From: Laura Gibbons <Laura.Gibbons@arun.gov.uk>
Sent: 19 October 2021 10:51
To: Planning.Responses <Planning.Responses@arun.gov.uk>
Cc: Simon Davis <Simon.Davis@arun.gov.uk>
Subject: RE: Planning Re-Consultation on: AL/112/21/DOC

Application No: AL/112/21/DOC

Site Address: Springfield Hook Lane Aldingbourne PO20 3TE

Description of Works: Approval of details reserved by condition imposed under AL/64/20/PL relating to conditions 10-surface water drainage, 11-discharge of flows & 12-surface water drainage system maintenance & management.

Title **DRAINAGE LAYOUT
2 OF 2**

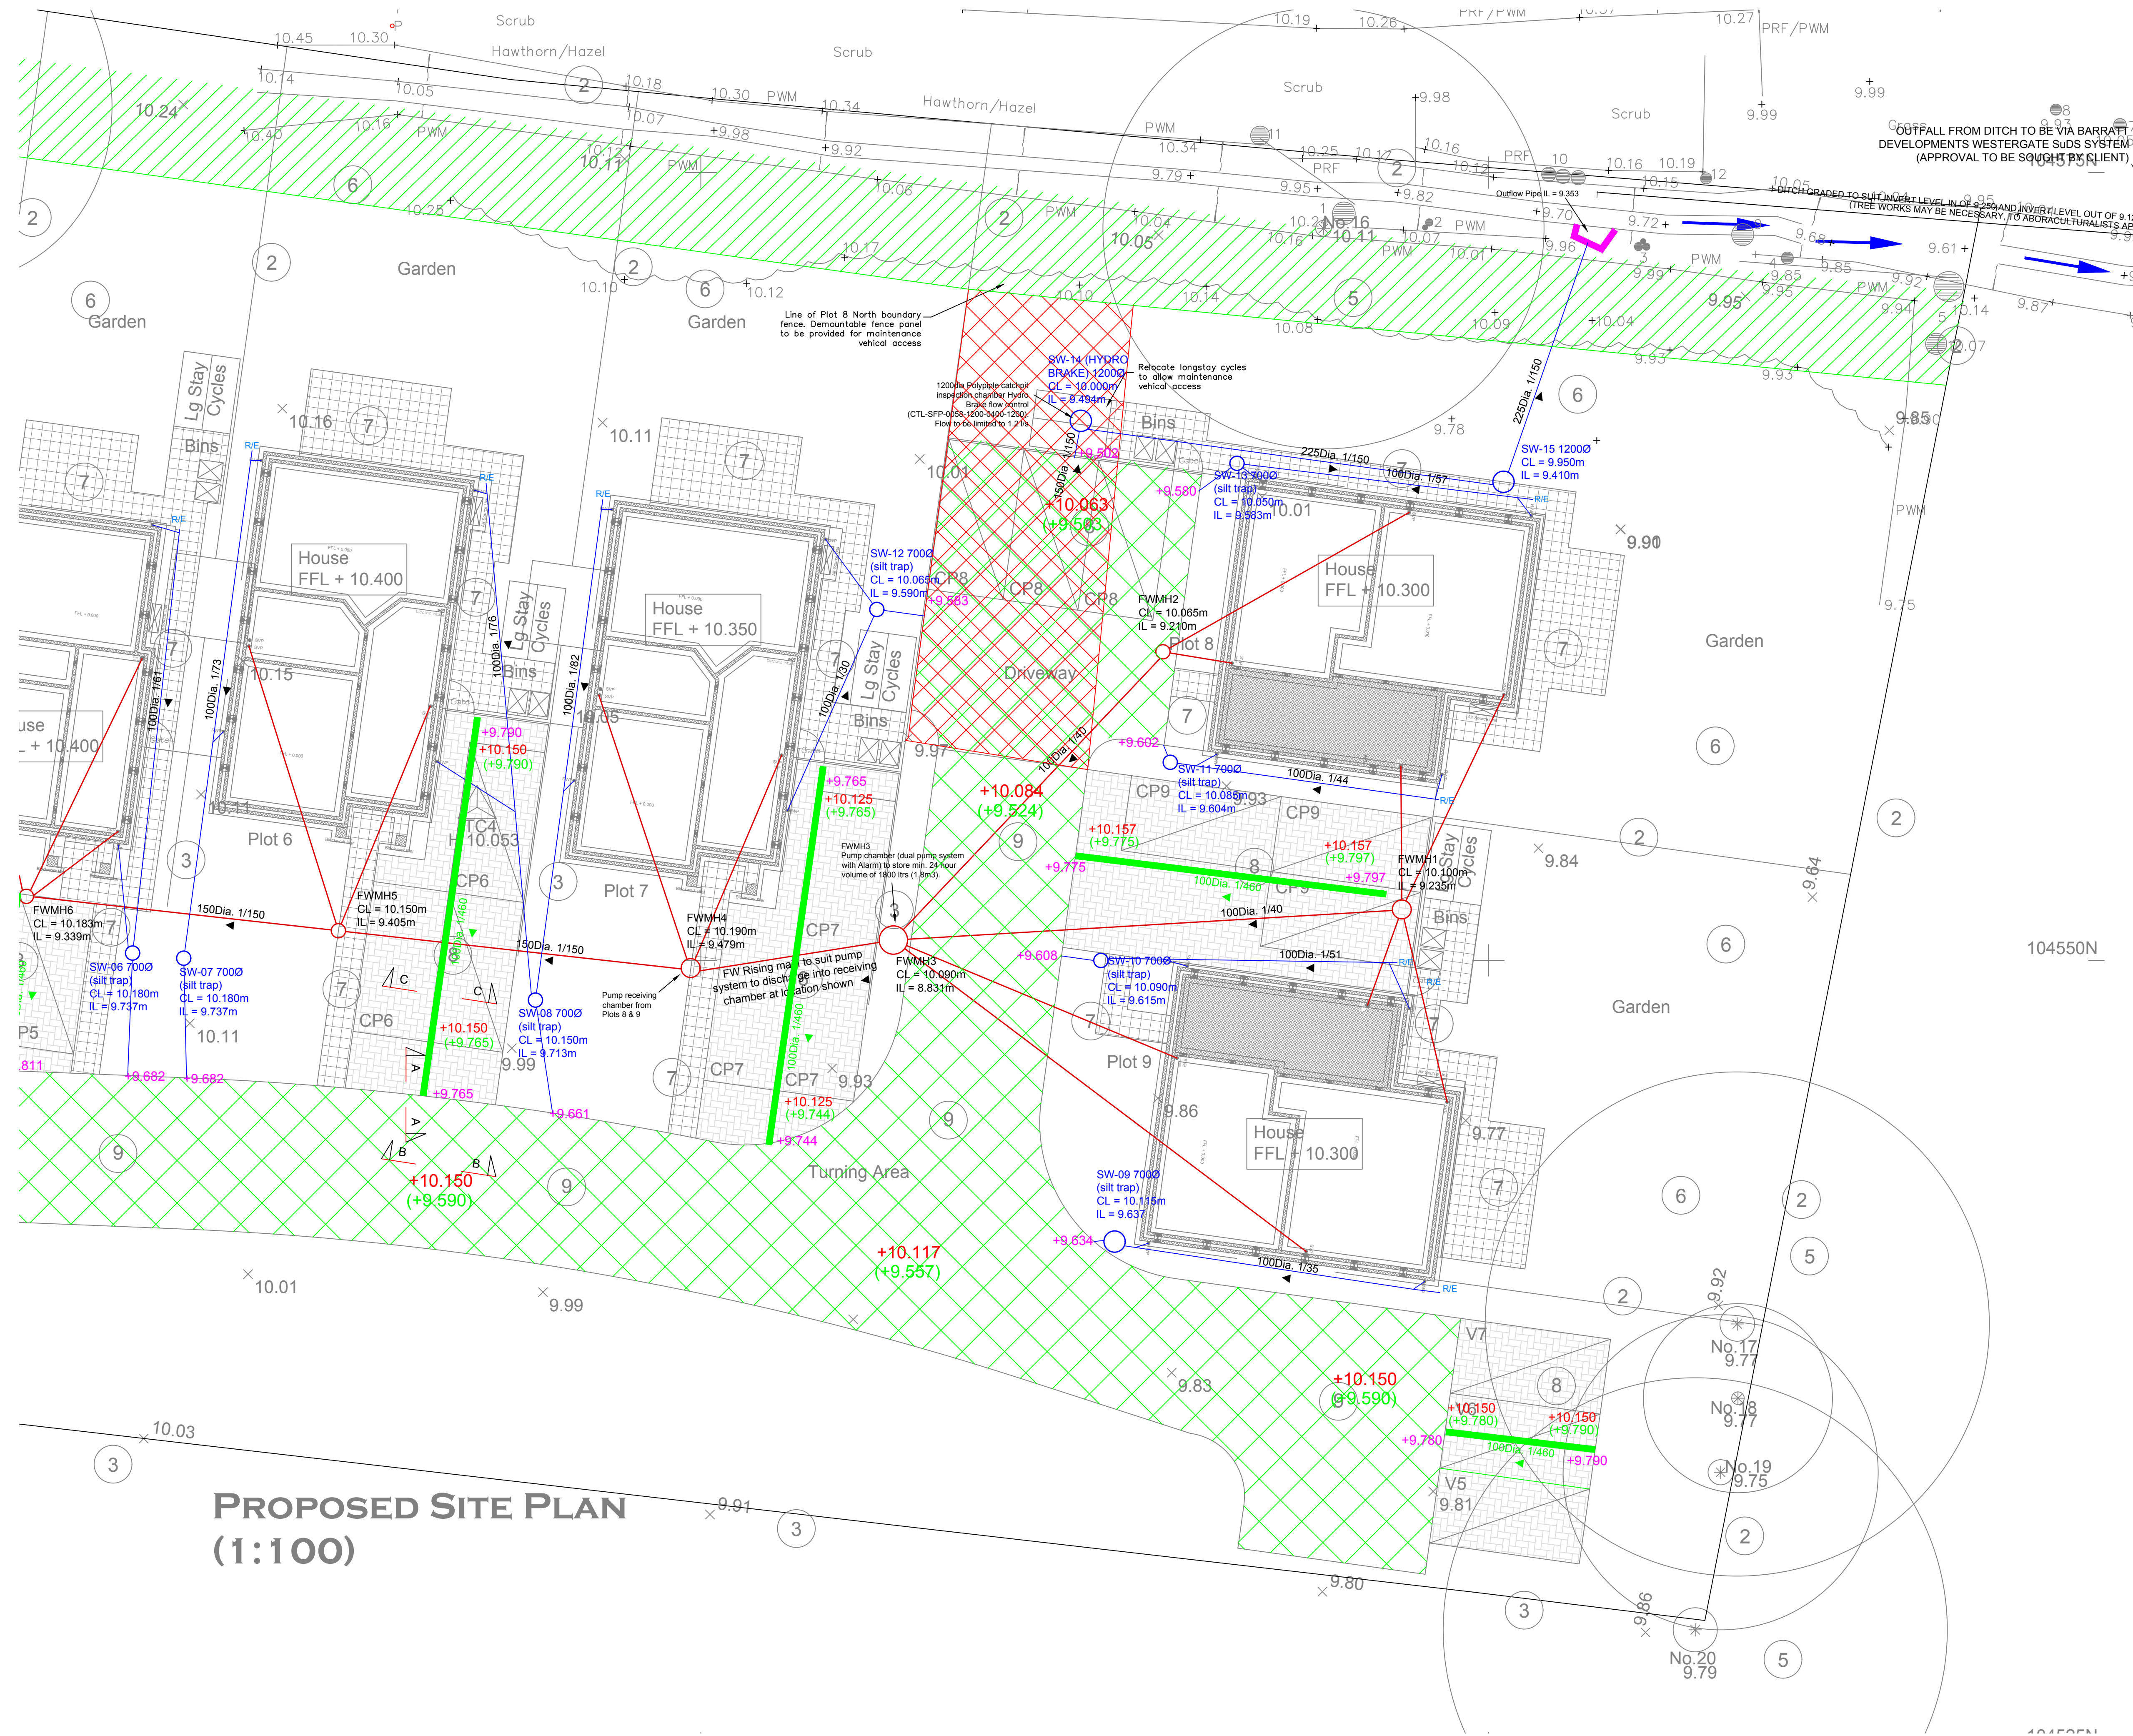
Please can evidence of land drainage consent be supplied, this should include evidence of the tree officers acceptance of proposals for the watercourse. Once this information has been supplied I will be happy to recommend discharge of conditions 10, 11 and 12.
